Our ref: MP06_0074-PA-55

Subject: Air Quality Management Plan

I refer to the Air Quality Management Plan (revision 9) submitted in accordance with the relevant conditions of consent for the Marulan South Hard Rock Quarry (MP06_0074).

Figure 2: Existing Air Quality Monitoring Locations

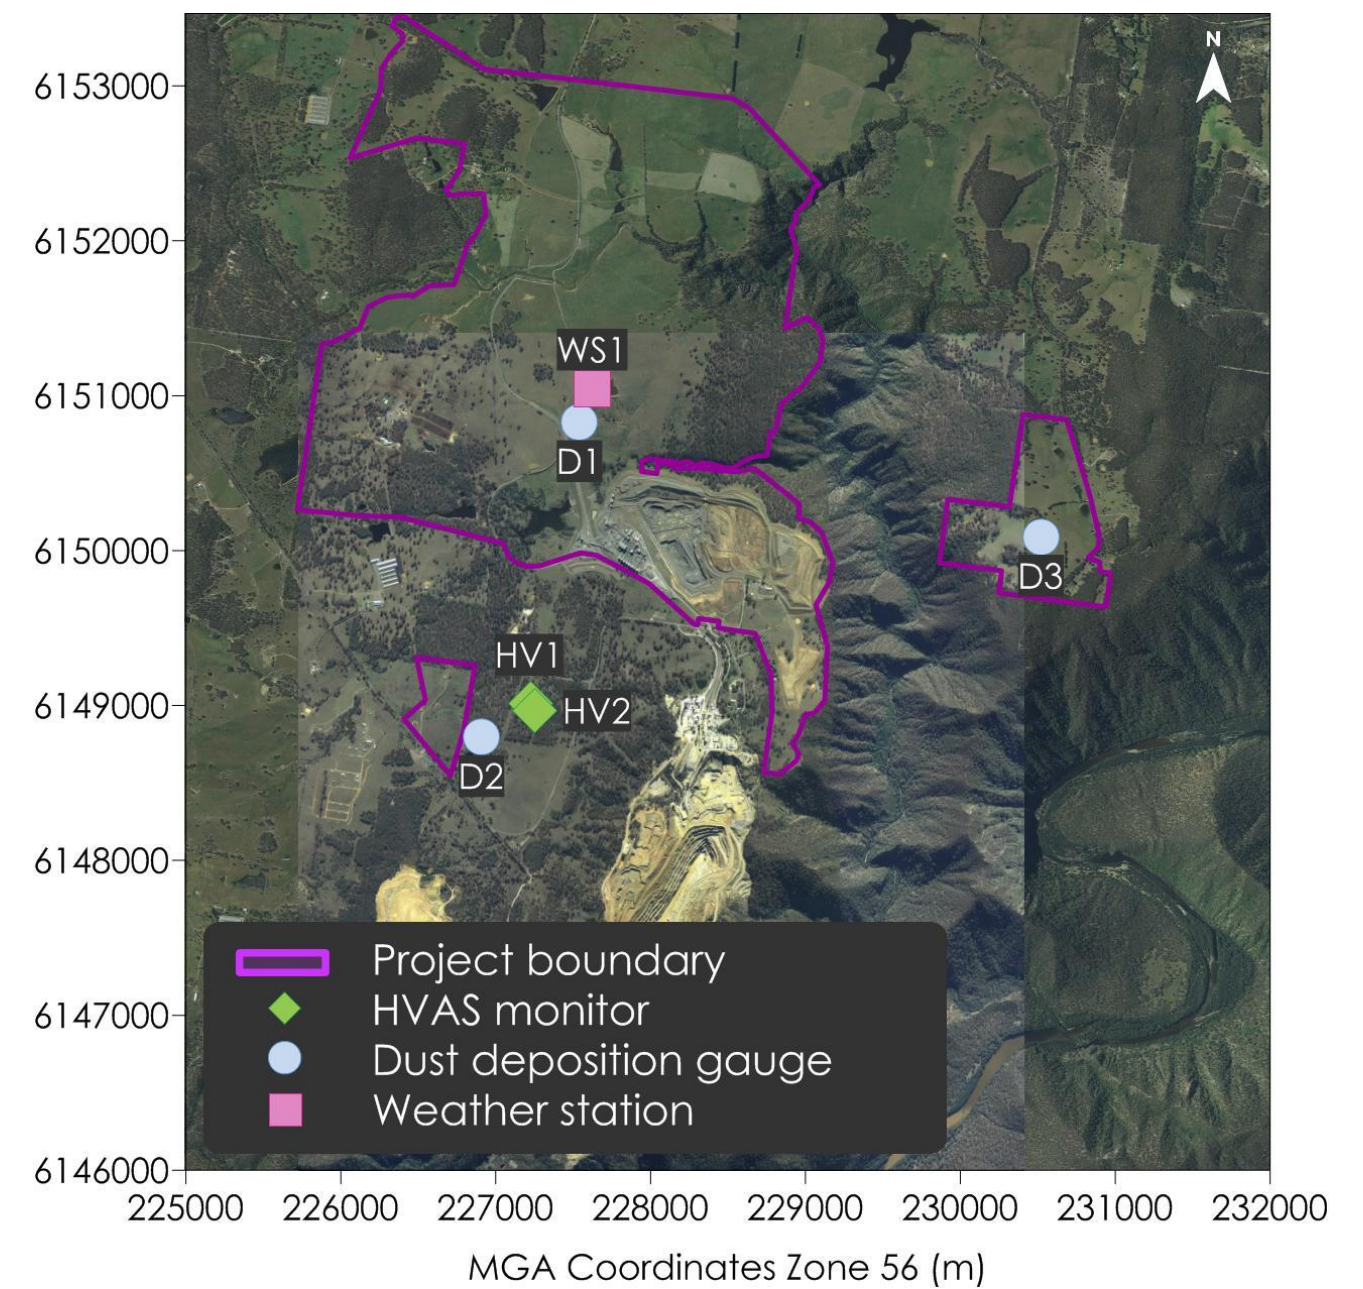
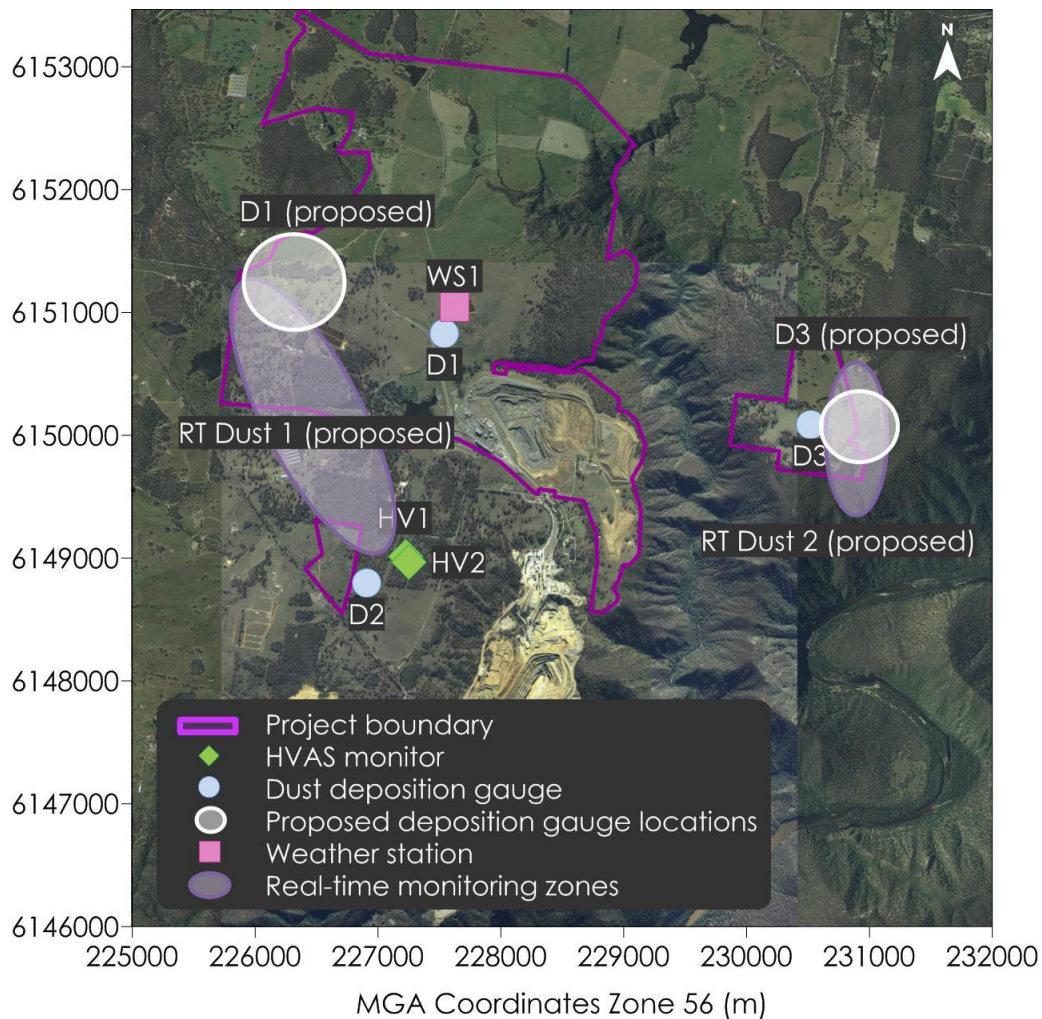
- update section 5 to reflect the approved modifications;
- update Tables 4 and 5 to include data from 2019-present, and update footnote 3 to Table 4;
- update section 6 on whether a portable real-time PM_{2.5} monitor has been obtained;
- combine air quality monitoring location Figures 2 and 4, including all locations in Table 10;
- incorporate section 6.3 - Modified Monitoring Network into the main text of the management plan; and
- update reference to the current *Protection of the Environment Operations (General) Regulation (2022)*.
